Office of
Environment
& Heritage

DOC15/331679
MP10_0054

Dargues Reef Environmental Assessment for Modification 3 (MP10_0054)

The Office of Environment and Heritage (OEH) is responding to your request for comment on the latest version of the Environmental Assessment (EA) for the proposed Modification 3 (Mod 3) of the Dargues Reef Gold Mine.

APPENDIX 4 BIODIVERSITY OFFSET STRATEGY

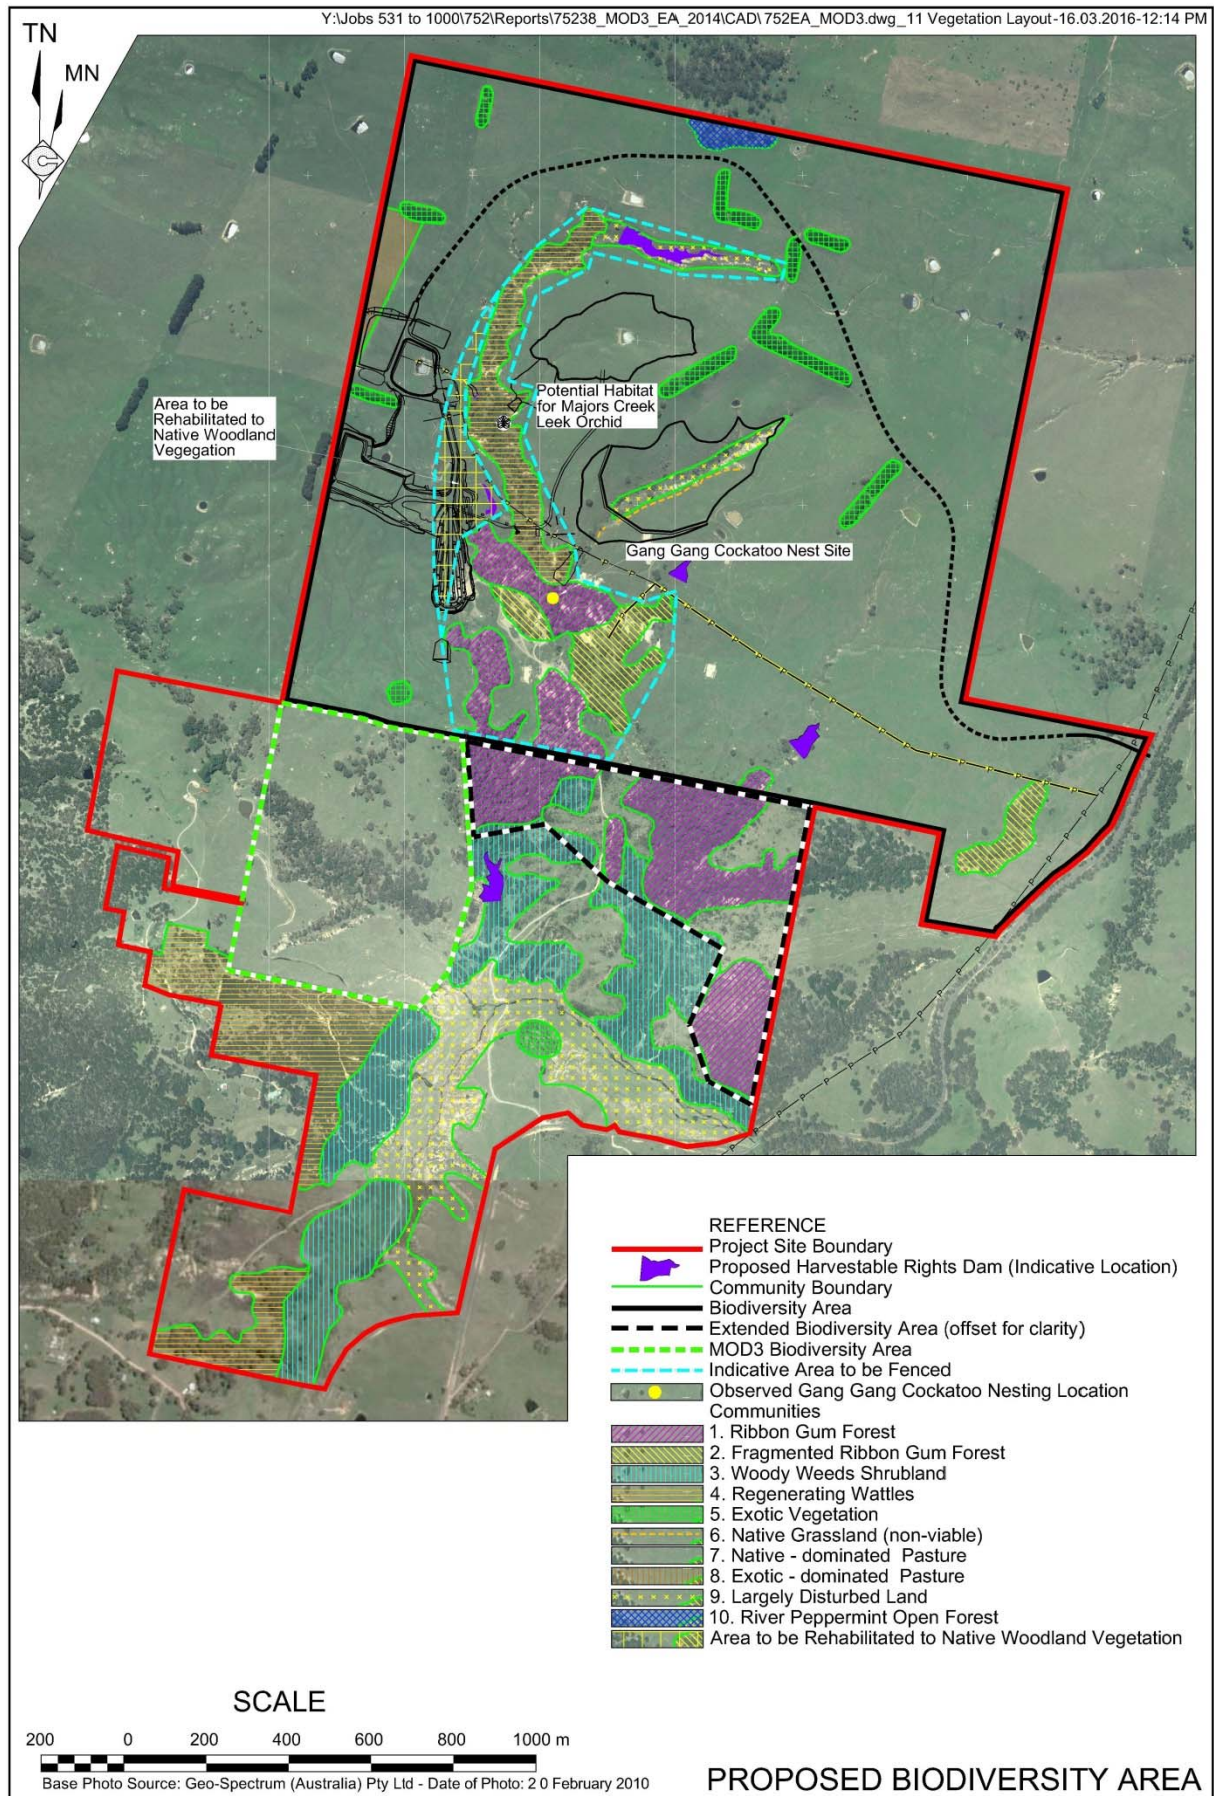
We note a new offset area has been identified in Figure 16 (Section 4.3.2). The new offset area of 33 hectares to offset the additional 19.5 ha of modified development provides a new offset ratio of 1.7:1 which in itself is low. However the overall offset package of 7:1 is still considered adequate.

INDICATIVE LAYOUT OF THE APPROVED
HARVESTABLE RIGHTS DAMS

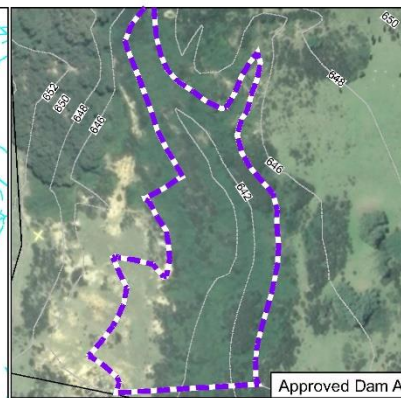
We note that the proposed harvestable rights dam HRD-E(r) will not be constructed due to its location within the proposed eastern waste rock emplacement (Mod 3 EA, July 2015 page 78). This is in contrast to the Mod 3 EA dated February 2015, which stated that dam HRD-E(r) was located within the unsurveyed 'Slings' property which is in the southwest section of the project site. How is it that this dam is now located near the eastern waste rock emplacement? Has the proposed location of dam HRD-E or the eastern waste rock emplacement changed since February?
